KITTITAS COUNTY

MEMORANDUM

TO: All Staff
FROM: Public Works Plan Review Team
DATE: July 18th, 2024
SUBJECT: SE-24-00021 Johnson Ag Utility Building

CIVIL SITE PLAN

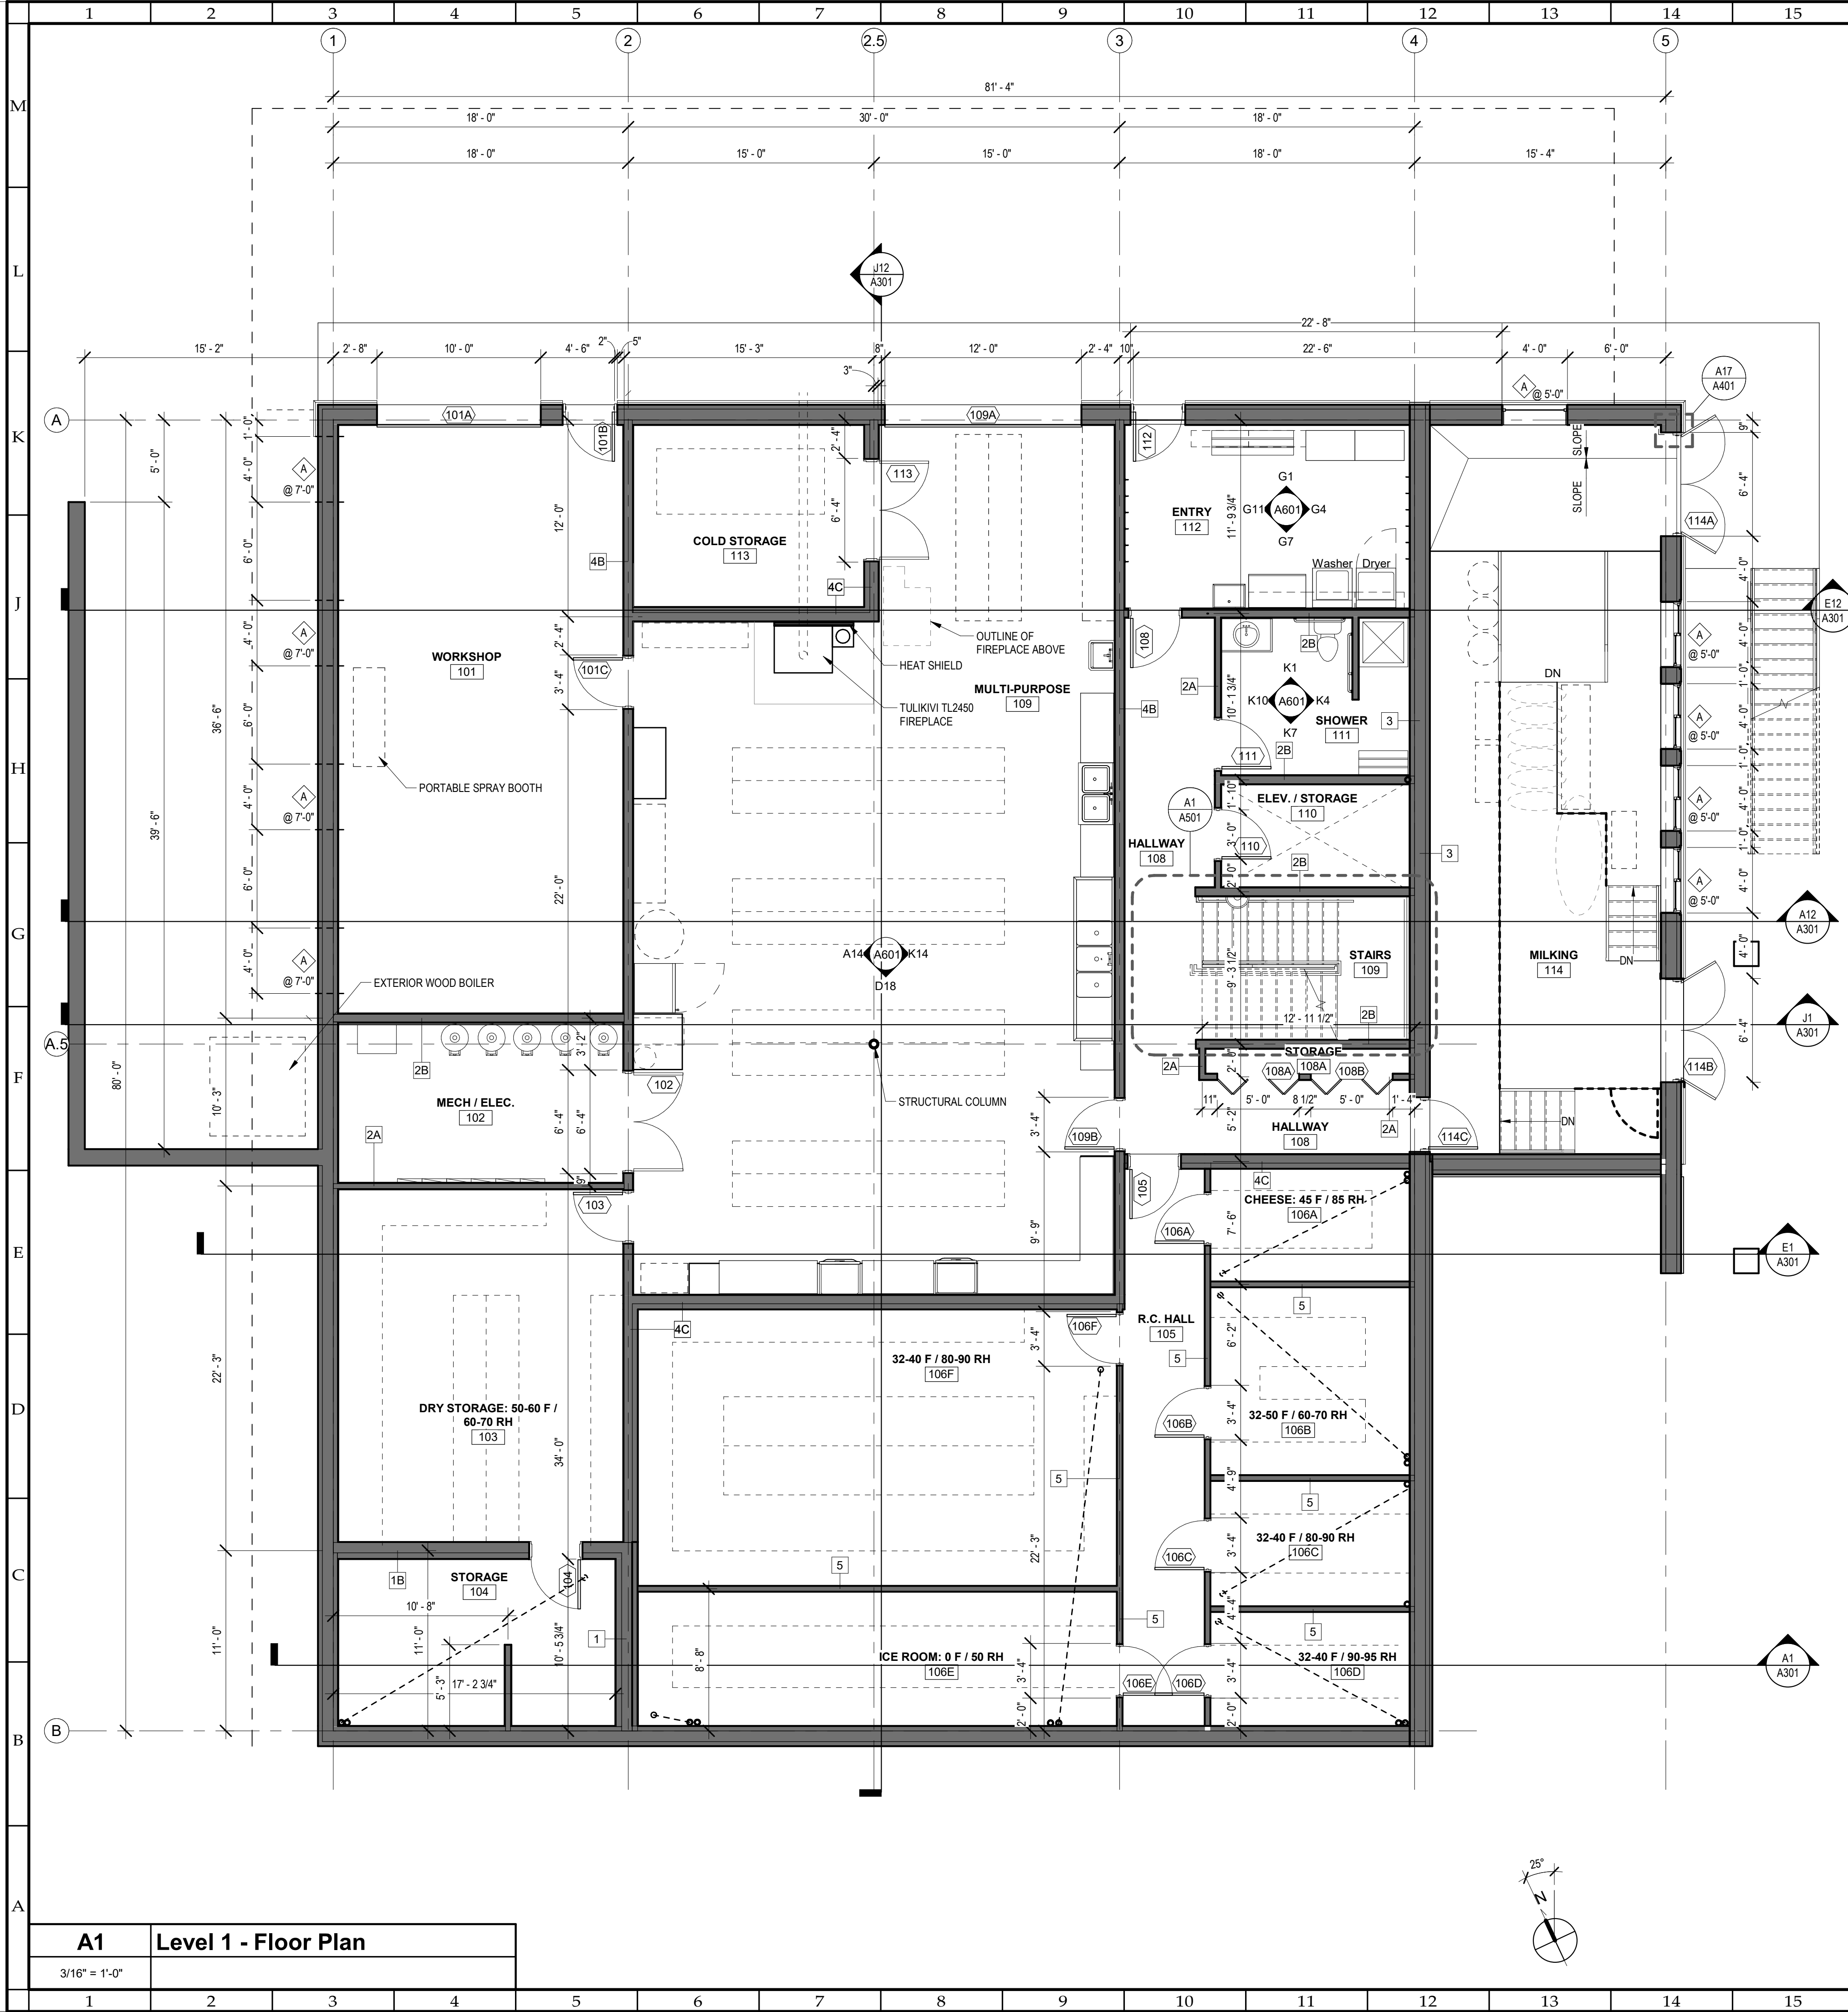
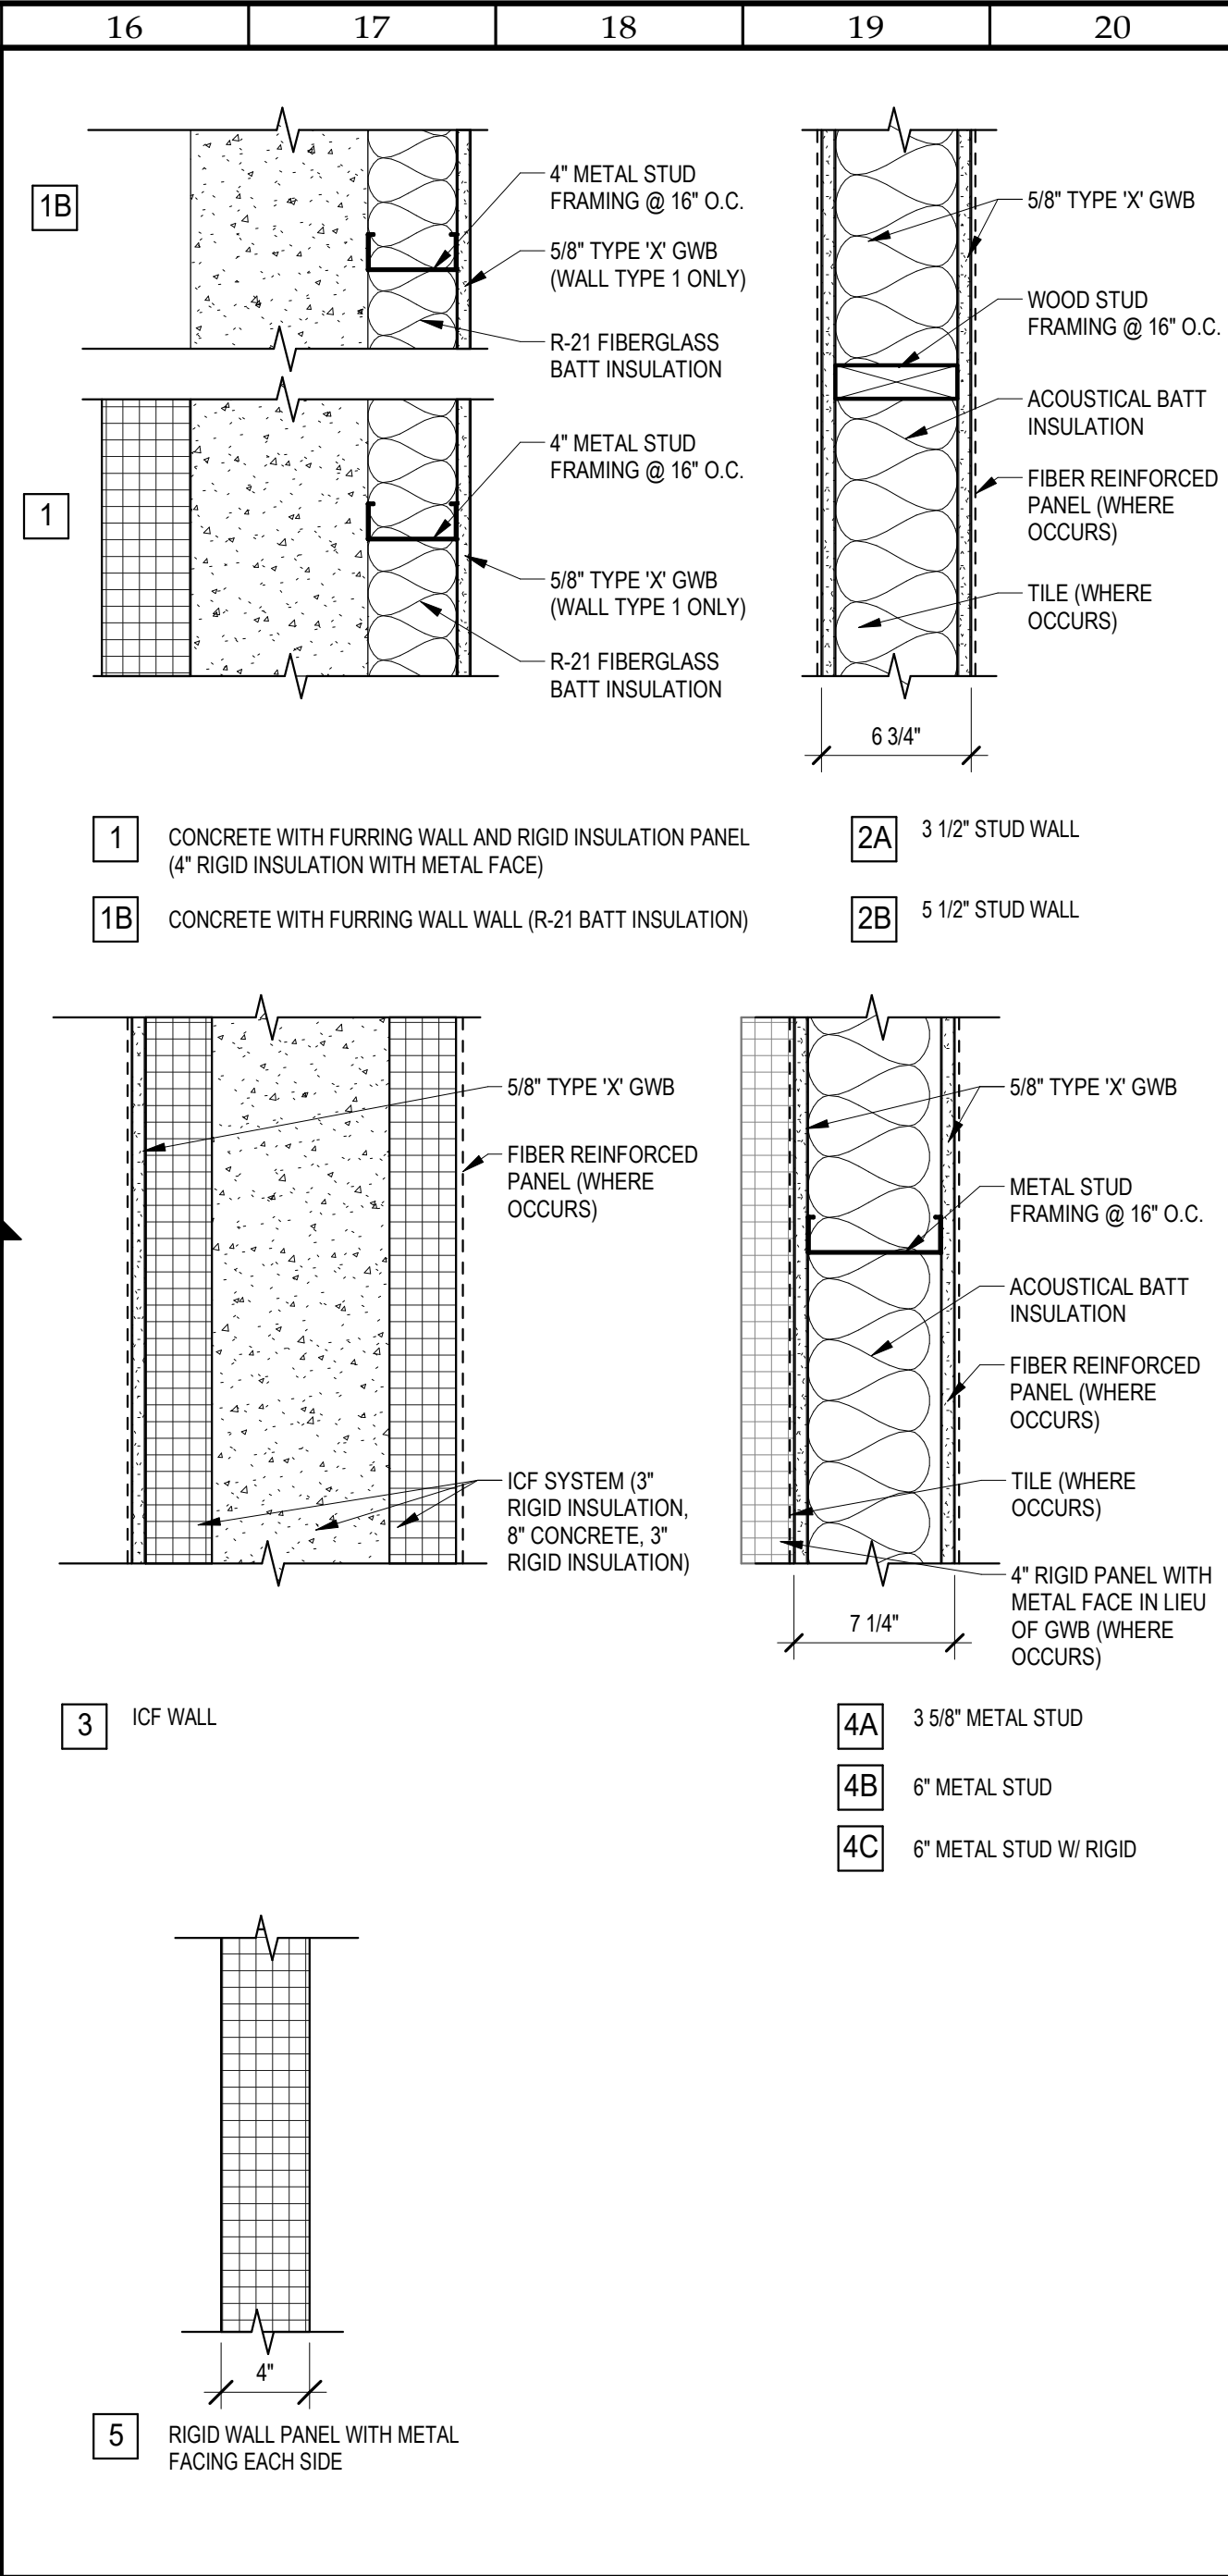
SURVEY	The provided documents included in the application do not adequately identify the West boundary of the subject parcel. From the information provided, it appears that the proposed barn may encroach or trespass on the parcel to the West. If the applicant does not wish to provide this information as part of the application, a Land Surveyor shall be utilized for the building layout and confirm it falls within the setback area of the subject parcel. (JT)
TRANSPORTATION CONCURRENCY	No Comments.
FLOOD	<p>Most of this property is located within the 100-year floodplain and floodway. All construction, including structures that are exempt from a building permit, must follow the guidelines within KCC 14.08.</p> <p>The floodway is highly restricted, and any development must demonstrate no rise in the level of the 100-year flood before being permitted. No new or substantially improved residential structures are allowed within the floodway.</p>

<p>All of the proposed development must be located outside the floodway and a certified survey of the parcel showing the location of the floodway is necessary to establish that the building will not encroach upon the floodway.</p> <p>Please call the Kittitas County Public Works at (509)962-7523 to discuss this project and permitting requirements. (SC)</p>
WATER MITIGATION/ METERING	Per KCC 13.35.027 all new uses of ground water require mitigation and metering. Proof of mitigation is required prior to applying for a building permit. (SC)
AIRPORT	N/A
